Application Reference: 2025/0083**Site Address:** Illton House, Roper Lane, Thurgoland, Sheffield, S35 7AA

Introduction: This application seeks full planning permission for the Removal of integrated garage roof and replace with first floor side extension to create extra bedrooms, demolition of existing single storey rear extension and replace with new single storey rear extension, to 2 storey detached dwelling.

First Floor Plan

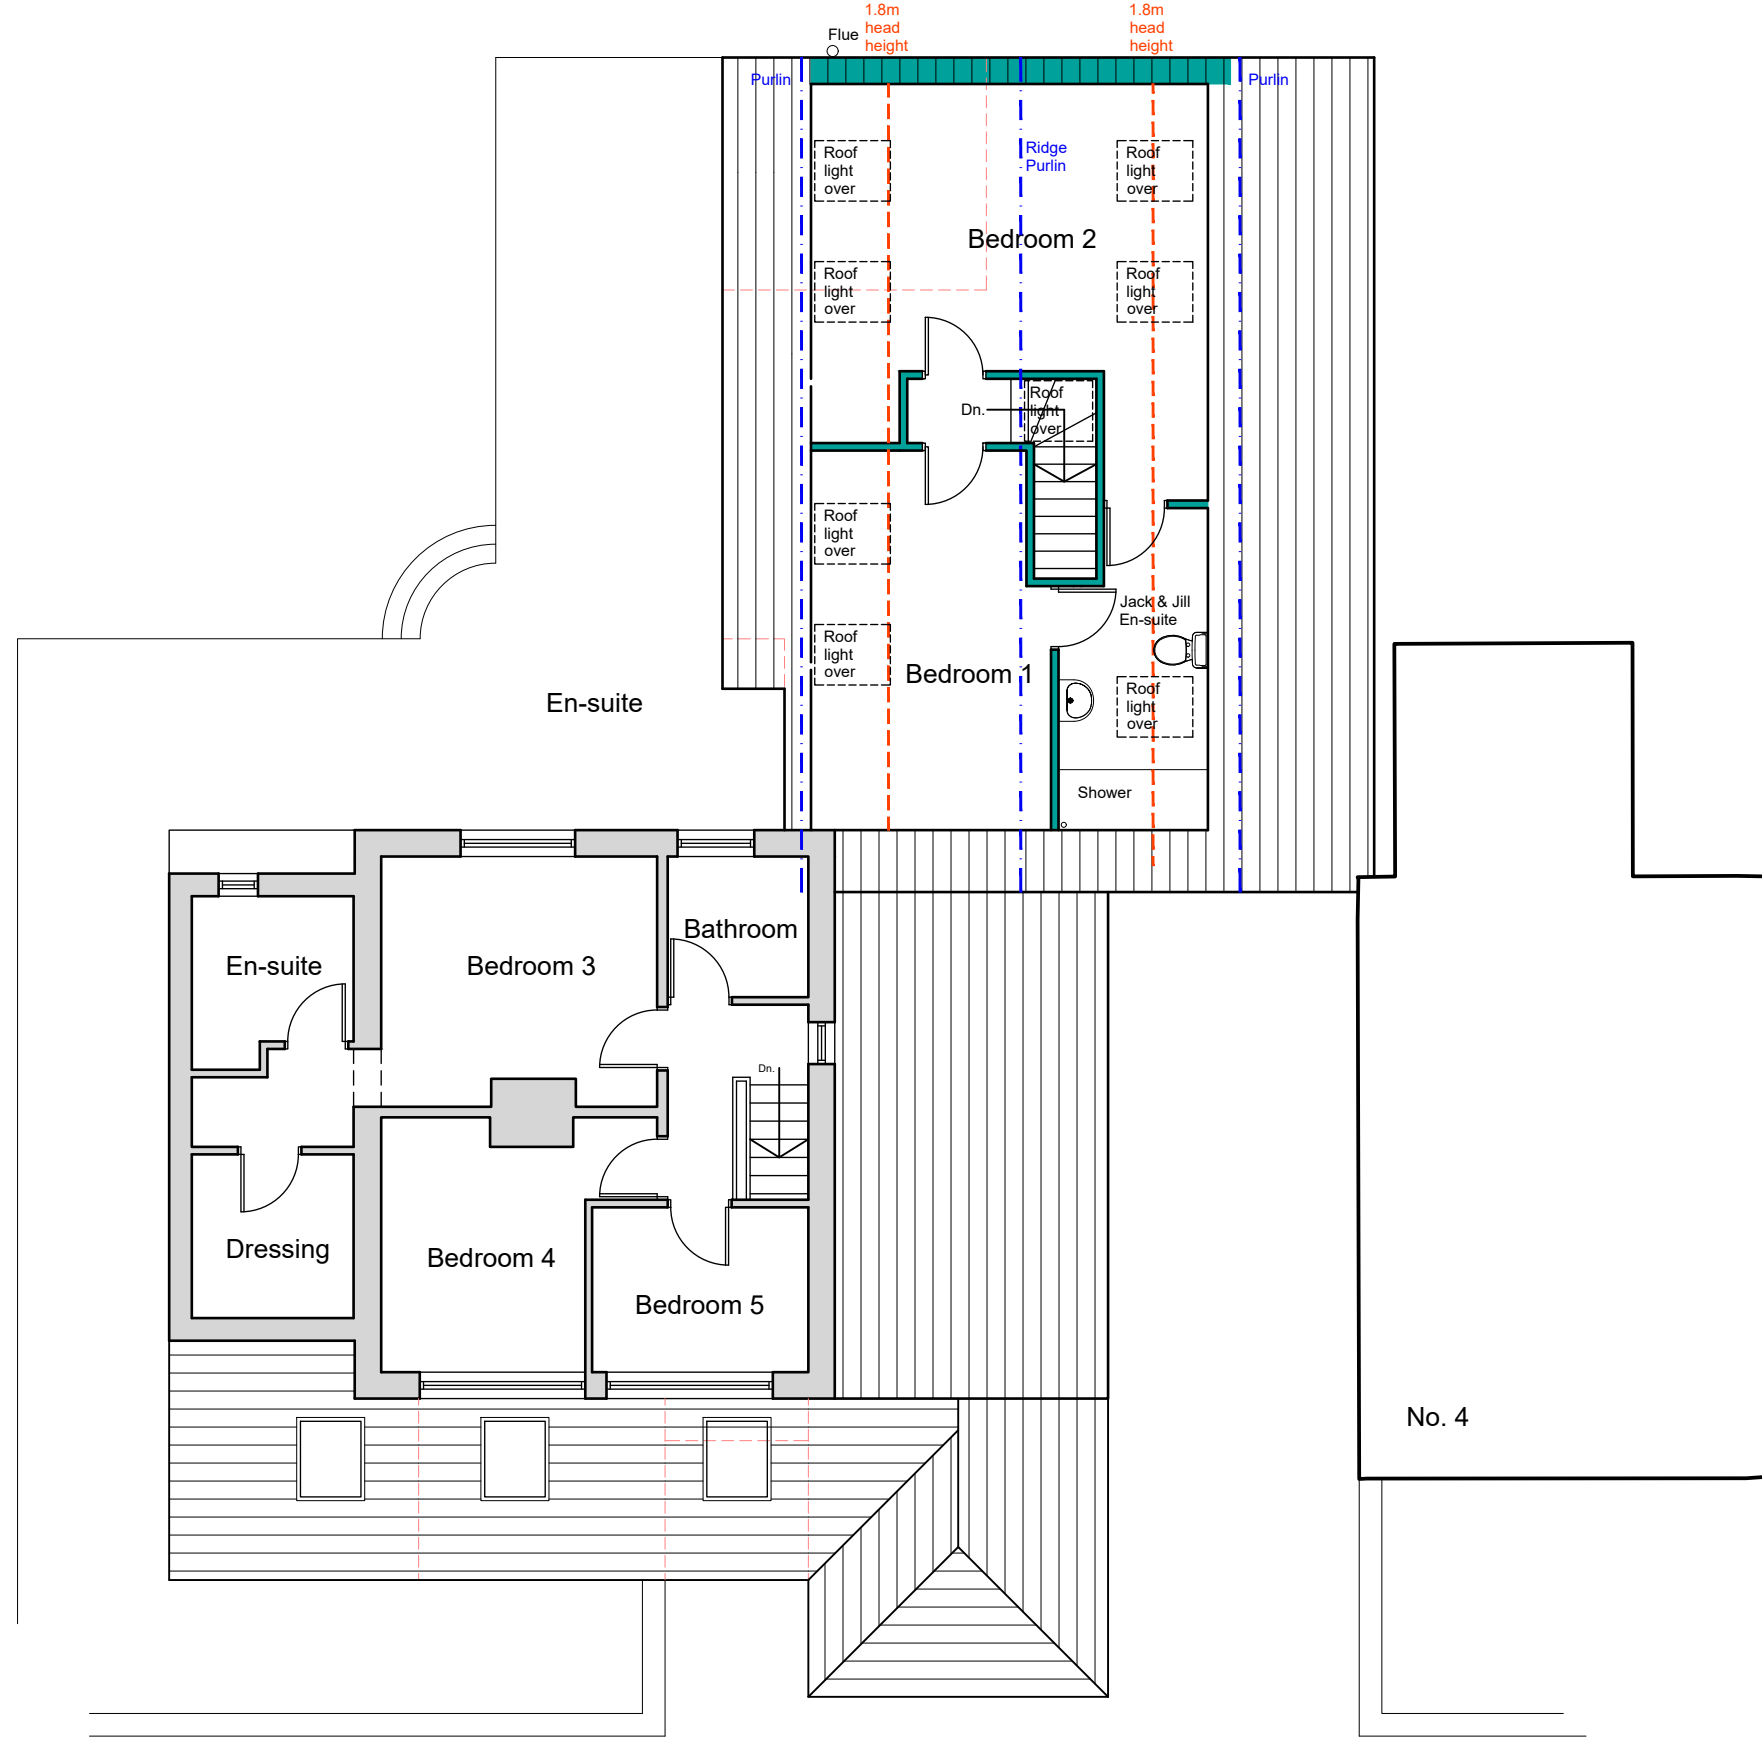
The most significant and prominent aspect of the proposal would be the enlarged new roof which is proposed to cover both the existing garage and new/extended rear extension, allowing additional living space to be created within part of the roof above the garage and the rear extension. Due to differing ground levels, the height of the roof is measured at 5.82m on the front elevation, 6.95m on the rear elevation, and 6.43m from the ground level on the northeast elevation. The proposed materials for the gable aspect of the roof are proposed stone/facing stone to match the original brickwork of the house, whilst the roof would be tiled.

The scale of the dwelling is already unusual and relatively large. The proposals are for a new roof above the existing garage, which would be internally combined with the new/ reconfigured extension to living space. These works would add additional height and volume above the garage and reconfigured rear extension which is already attached to the garage. The increase in height would be at a considerable distance from the highway and be lower than the existing 7.5m of the main roof of the dwelling. With a gable style roof, whilst the maximum ridge height of the roof, viewed from the Roper Lane is approximately 5.81m high, this level drops as the roof slopes to both sides. Because of land level differences, the roof is approximately 6.95m when viewed from the rear of the house, but again this remains lower than the 8.65m height of the main dwelling. Whilst the proposed roof height would have an impact on the scale of the dwelling, some of this impact would also be positive by harmonising the garage and rear extension under one new roof. Additionally, with such an unusual design of dwelling as a starting point, and with the green wooden cladding being replaced by stone or facing stone of a similar appearance to that of the main house, the overall impact on scale, design and character of the dwelling, and by association the street scene would be considered as limited.

The second aspect of the proposal is for the demolition and replacement, or renovation of the existing ground floor extension which is attached to the northwestern elevation of the garage. The replacement would include two small increases in the footprint of the existing ground floor extension. The first increase would be a corner infill of approximately 8.35m at the side and rear elevation whilst the second extension is of a relatively insignificant size of approximately 0.55 sqm and would be located close to where the side elevation of the extension adjoins the house. With the new proposed and heightened roof covering both the garage and rear extension the proposed extension would include first-floor living space within the new roof. Overall, the proposal would have a generally positive impact regarding the design and character of the

Objections have been received about the perceived impact of the proposed new garage and extension roof. The nearest dwelling is No. 4 Roper Lane which is already overshadowed but not overlooked by any windows from the existing garage. With the proposed gable roof design of the roof, which has a significant slope away from the neighbouring dwelling, it would only be expected to have little or no additional impact on their amenity. Dwellings further away from the proposal would have even less of an impact from the proposal.

Privacy concerns were raised about proposed roof lights located within the northeastern elevation of the proposed new roof, these would potentially overlook Cliffe Cottages, and a second concern was raised about a ground floor door within the north elevation of the former garage. The original proposed window within the door was already detailed as having frosted glazing and remains so on the amended plans. The proposed rooflights, although unlikely to have overlooked any neighbouring dwellings, are now also listed as having frosted glass. With both these issues resolved, no other proposed windows overlooking neighbouring dwellings, and with no other concerns raised being deemed as material planning considerations, the impact of the proposal on privacy or other neighbouring amenity would be judged to be limited.

- There were concerns over the proposed materials and size of the proposal. Revised plans with modest height amendments but greatly improved material choices were submitted, along with confirmation of frosted glazing in windows potentially overlooking neighbouring dwellings.
